Our Ref: TR010025

Date: 3 April 2019

Application by RiverOak Strategic Partners for an Order Granting Development Consent for the upgrade and reopening of Manston Airport

Notification of Procedural Decisions including variation to the Examination Timetable

Figure 14.9
Locations requiring further
assessment

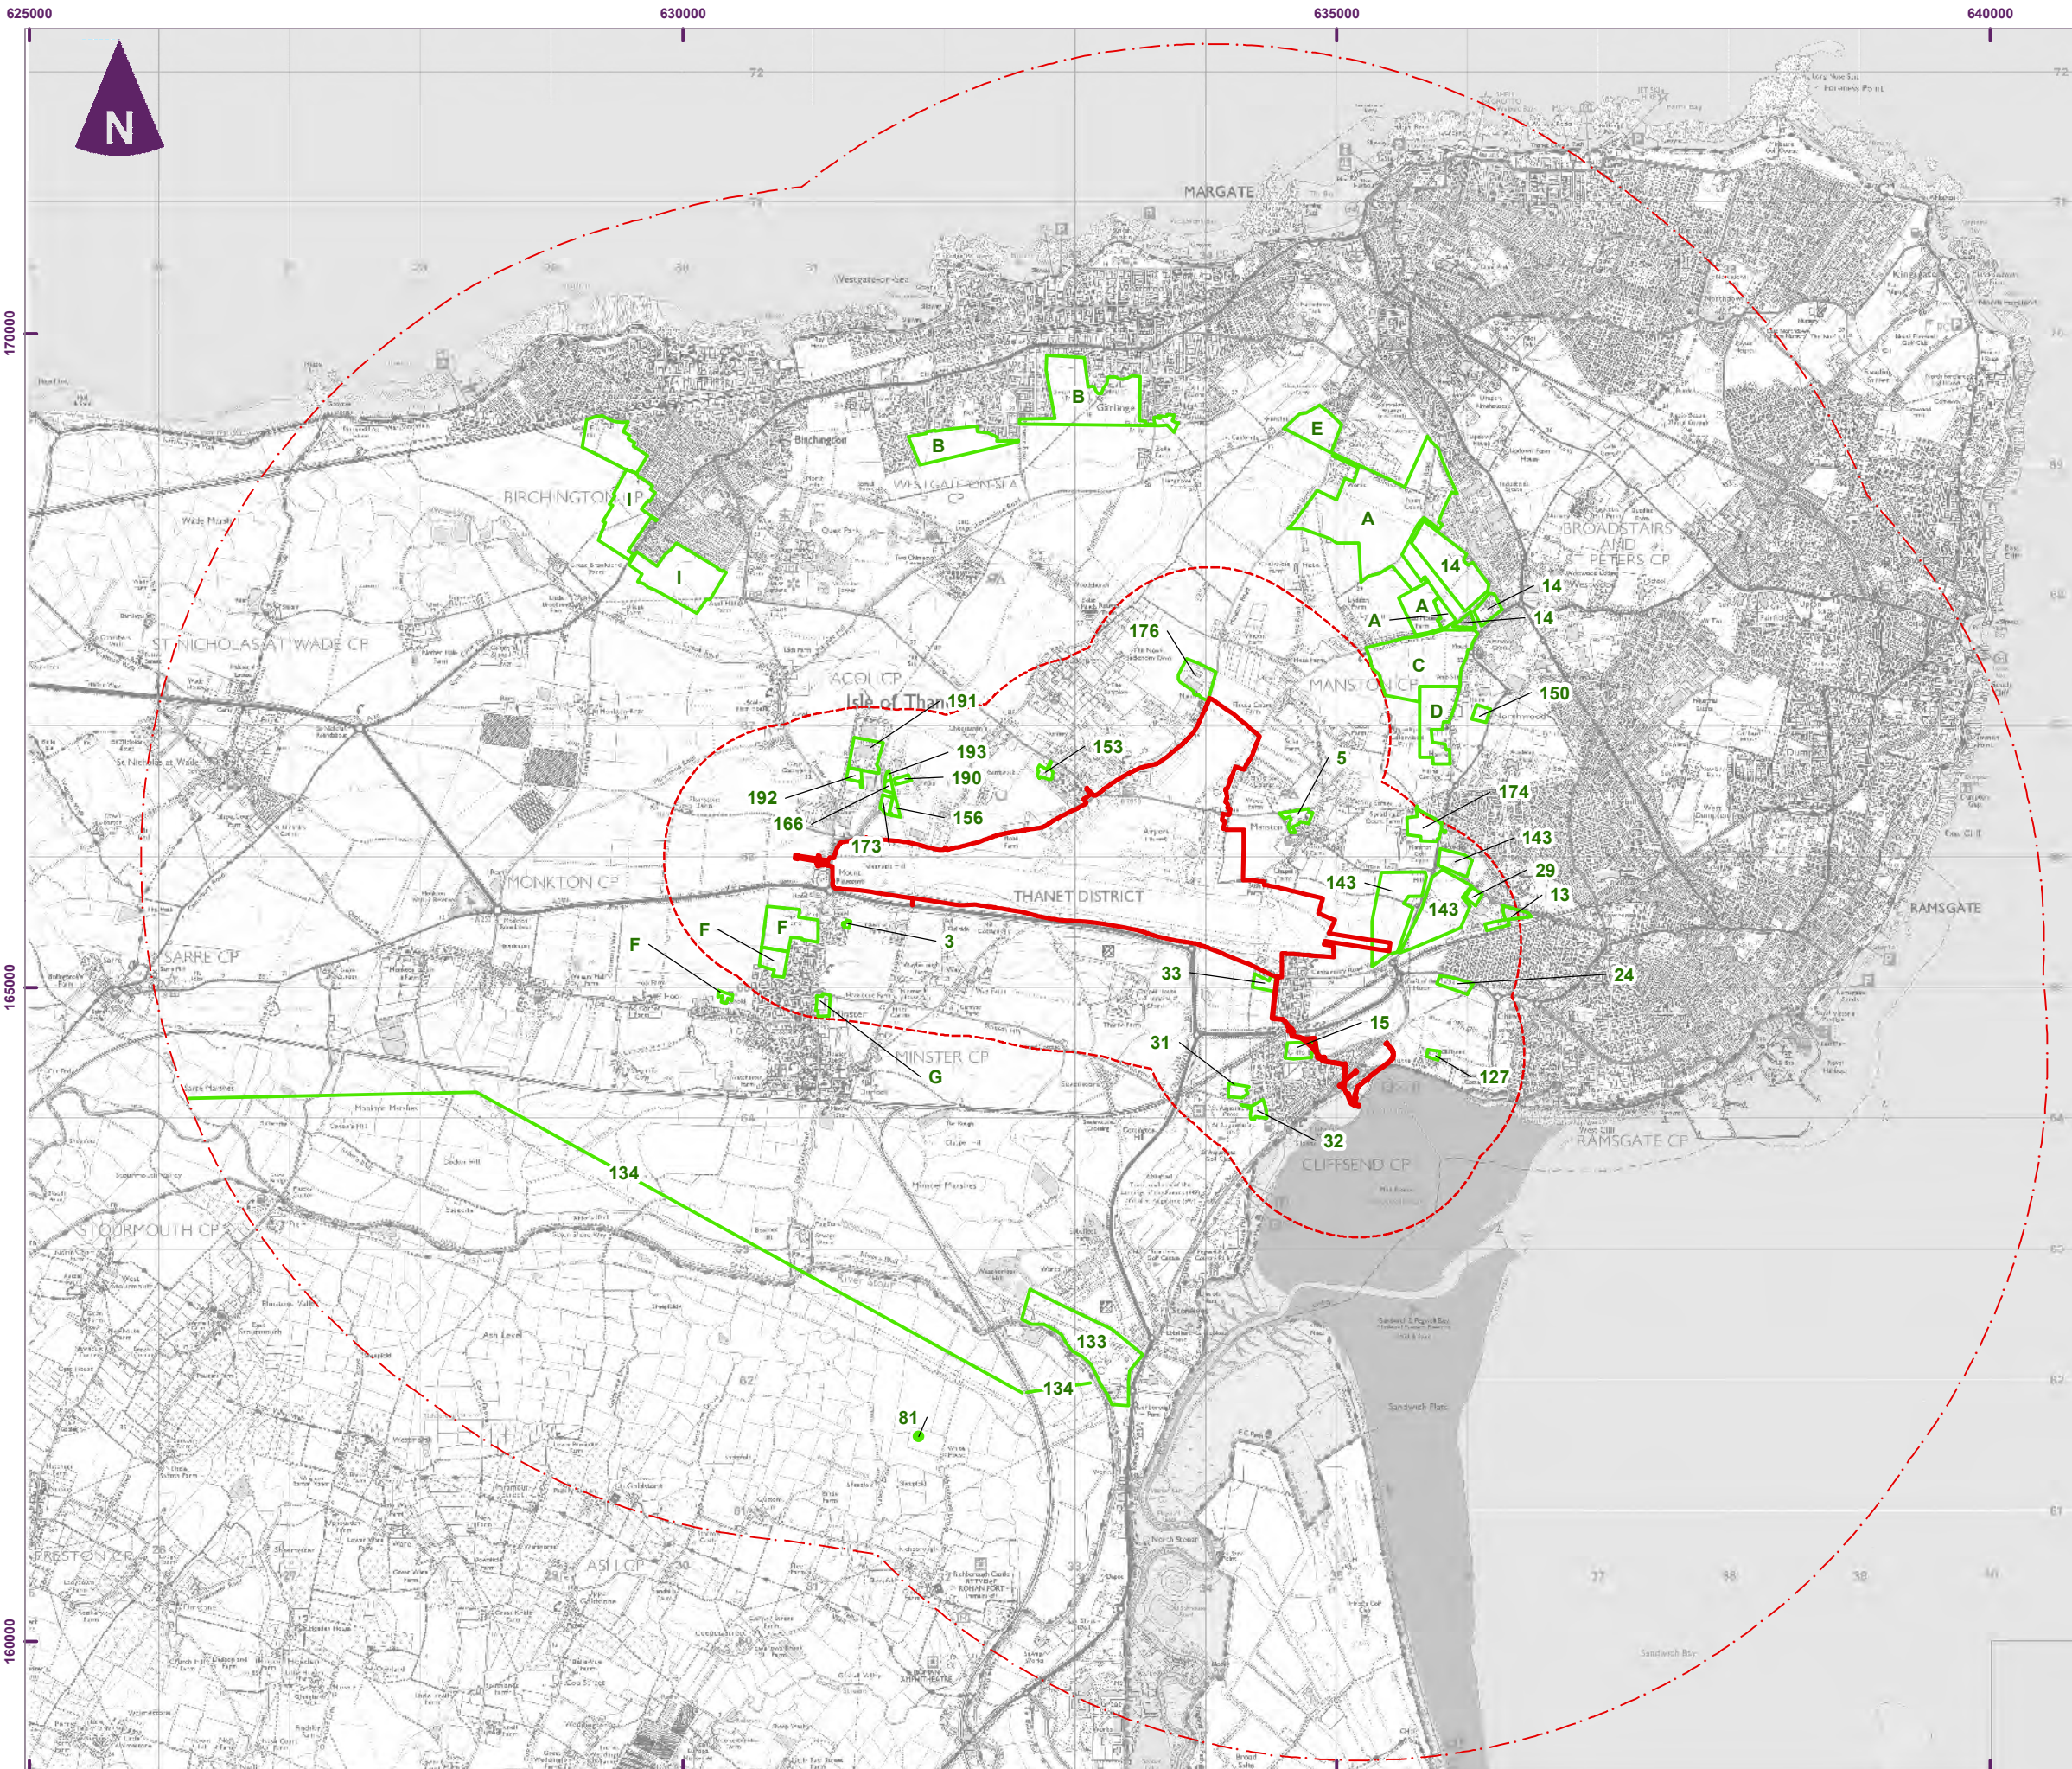
- iv. Table 14.20 identifies link 34 as needing further consideration (so does Figure 14.9), but it is not considered further in section 14.10.
- v. The 'AM peak all vehicle' % increase for link 39 Manston Road north of NGA link is highlighted in red (22%) in Appendix 14.3, but this is not reflected in Table 14.20 of the main document and has not been considered further.
